Discharge of Surface Water Management Planning Conditions Summary Note

The Civil Engineering Practice
11 Tungsten Building
George Street
Fishergate
Sussex
BN41 1RA

Project	Bonhams Field
Project Number	23018
By	Martin Kempshall C Eng MICE
Date	22 December 2020

PERMEABLE CONCRETE BLOCK PAVING
DRIVE CONSTRUCTION DETAIL
Scale 1:20

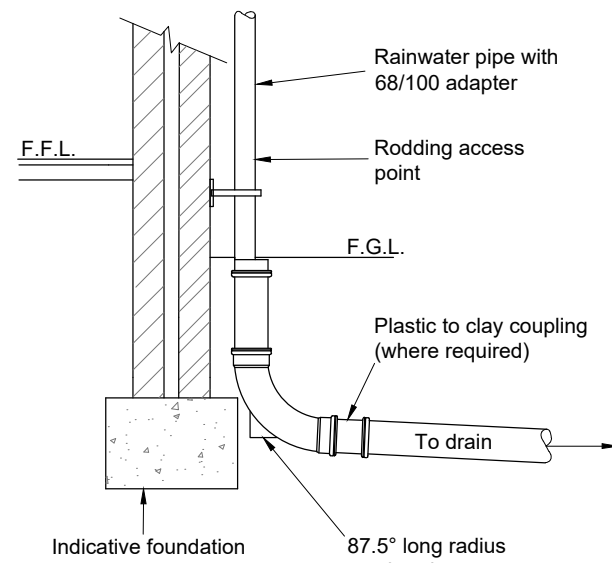
6. Once further site investigation is completed we will provide further comments. Based on a quick overview it is not evident whether the base of permeable paving is above peak groundwater levels, nor that all distribution tanks are at least a minimum of 5m from buildings.

- 6.5 Testing was completed in strict accordance with BRE Digest 365 methodology, at the level of the proposed base of the infiltration features at 0.7m to 0.8m below existing ground level, above peak groundwater levels, with all trial pits sufficiently drained and recorded.

- 6.7 Groundwater monitoring completed during Winter 2019/2020 identified groundwater levels of between 0.95mbgl to 1.77mbgl below existing ground levels confirming an unsaturated zone can be maintained between the base of the shallow surface water infiltration storage blankets and the maximum recorded winter groundwater level.
